Subject: Y/140/20/DOC - Cinders Lane Nursery and works to the rear, Cinders Lane, Yapton, BN18 0JJ

In relation to the above address, EH is not able to provide comment on the discharge of conditions 6 (contaminated land) until the Preliminary Site Investigation Report by Soils Ltd. (ref.: 18115/DS, dated February 2020) has been provided for review.

Scale : 1:500 @ A1 Date : SEPT 2020
Drawing No : 97_17_103

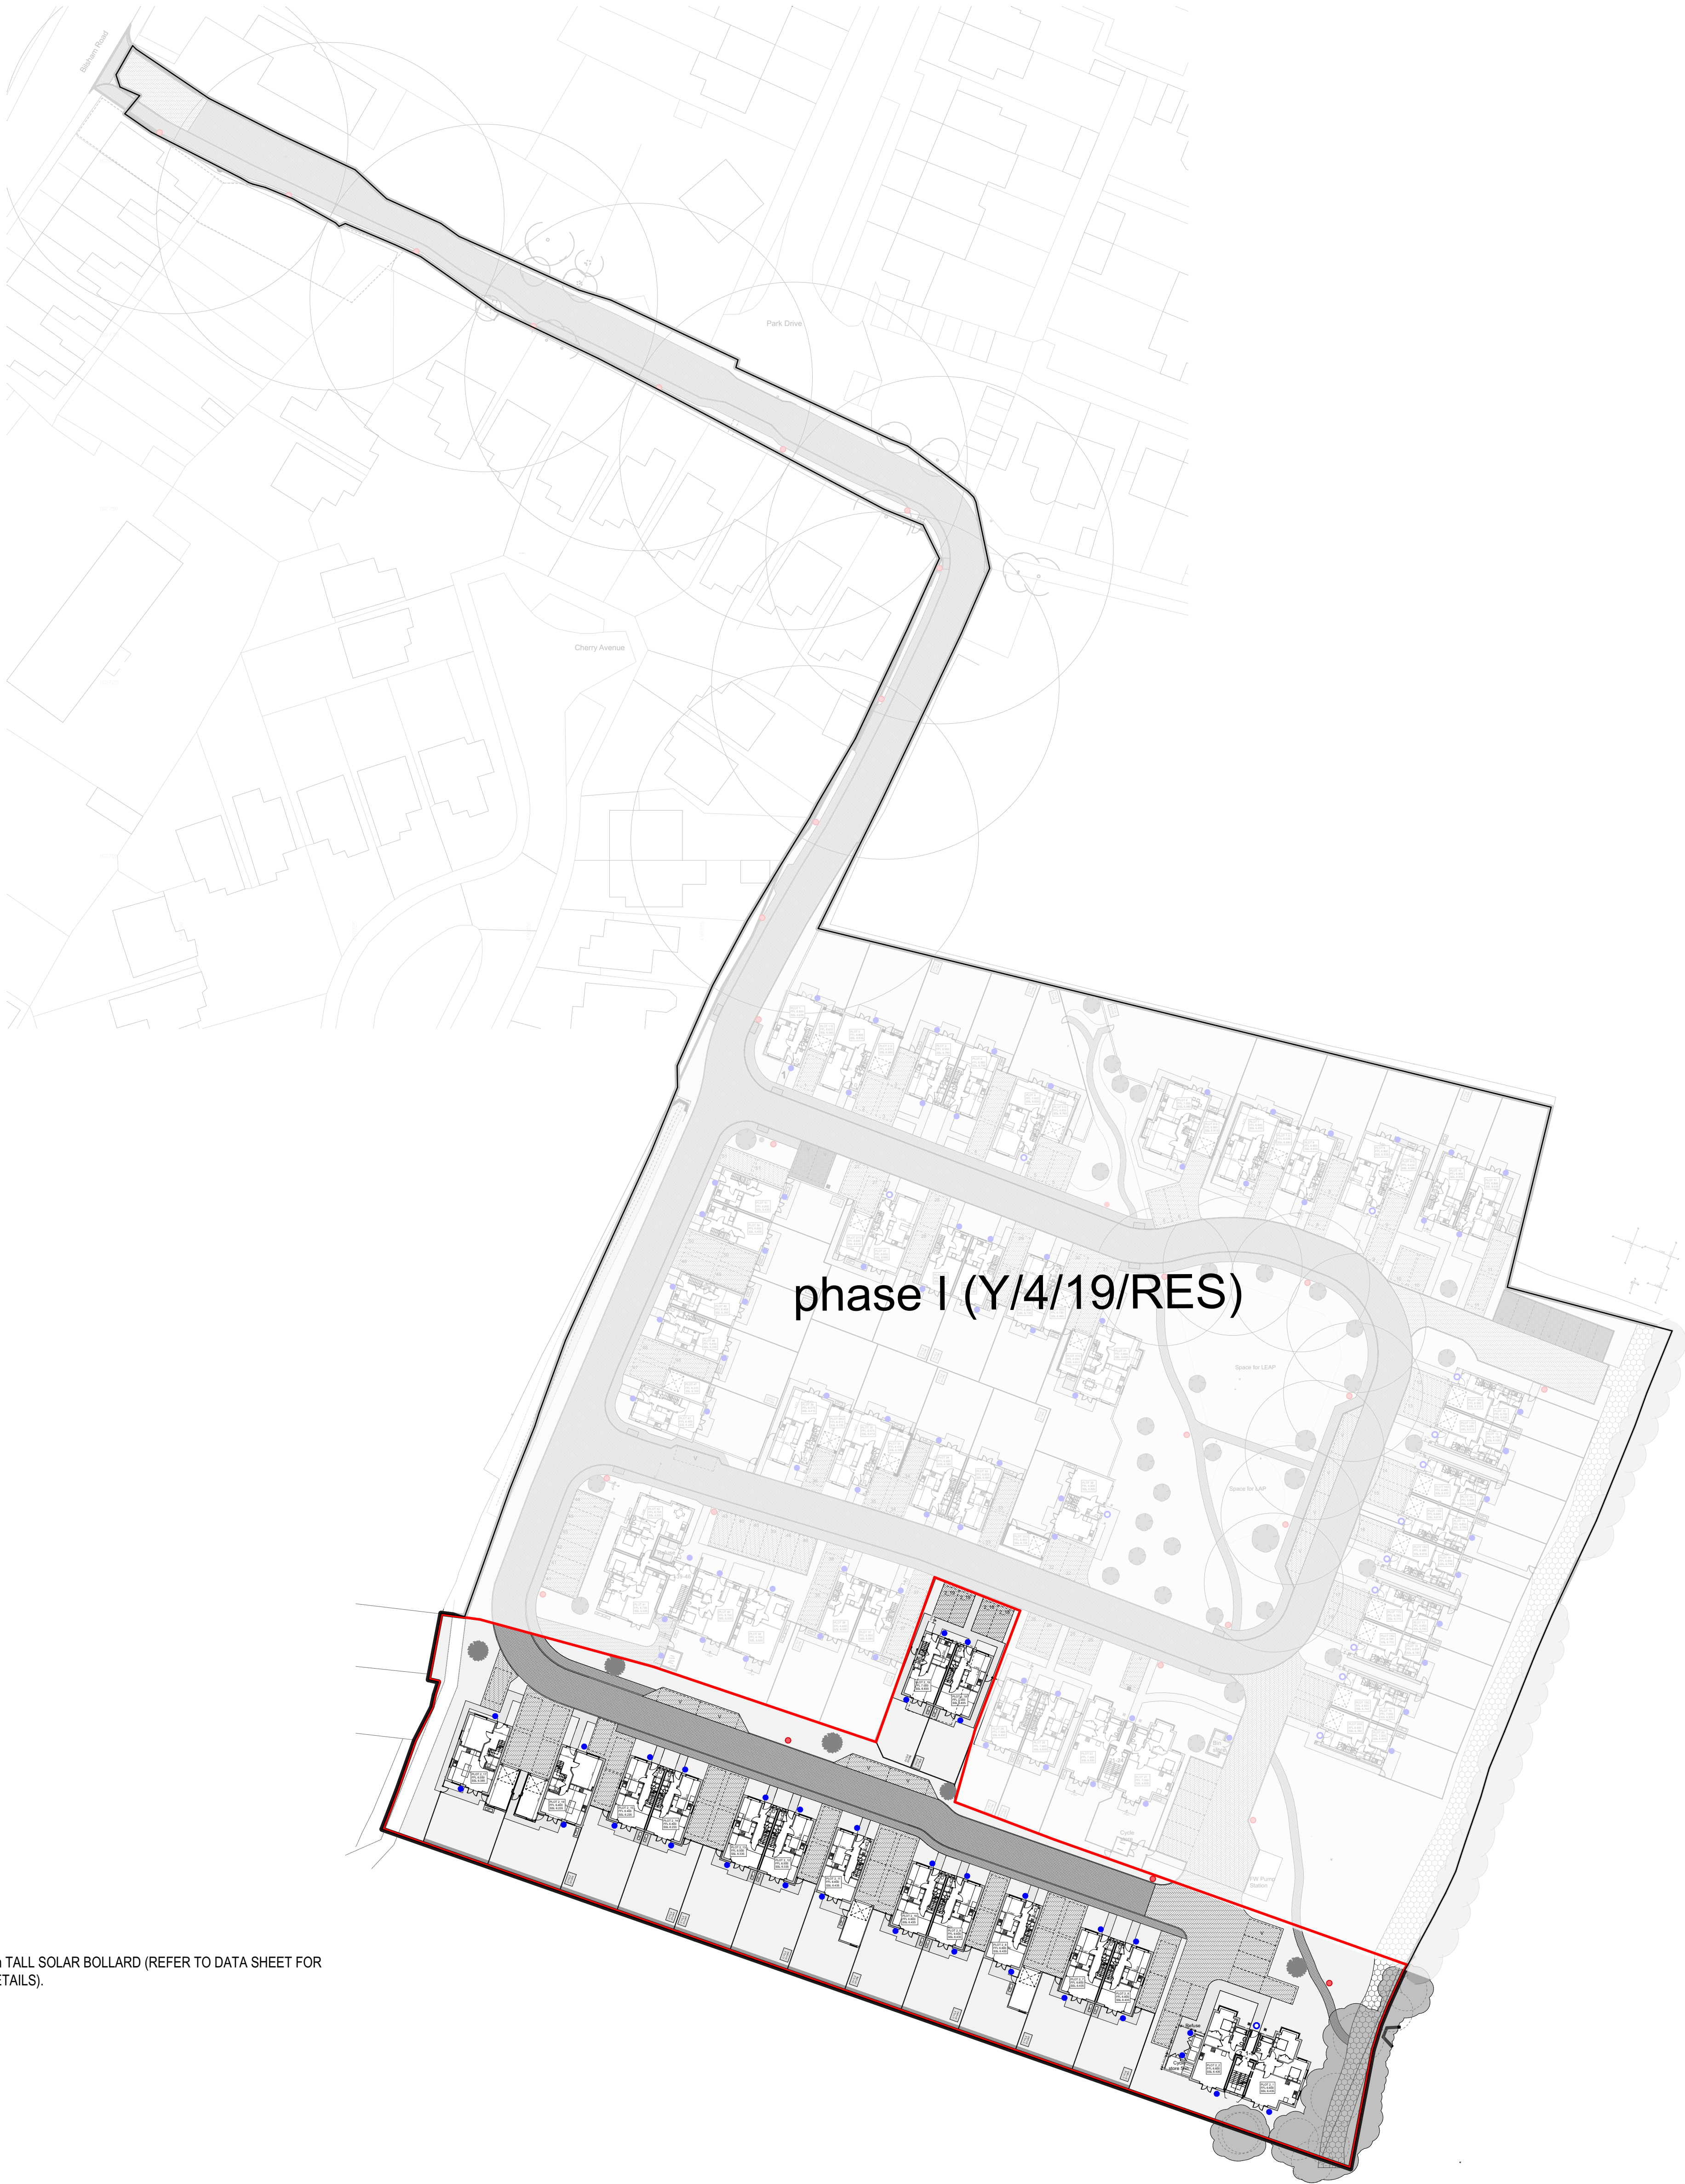
With regard to the discharge of condition 19 (lighting), the external lighting plan and light detail sheets should please be updated to include detail the light spill from each installation point. Please also note that EH cannot comment on the potential impact on bats in the vicinity.
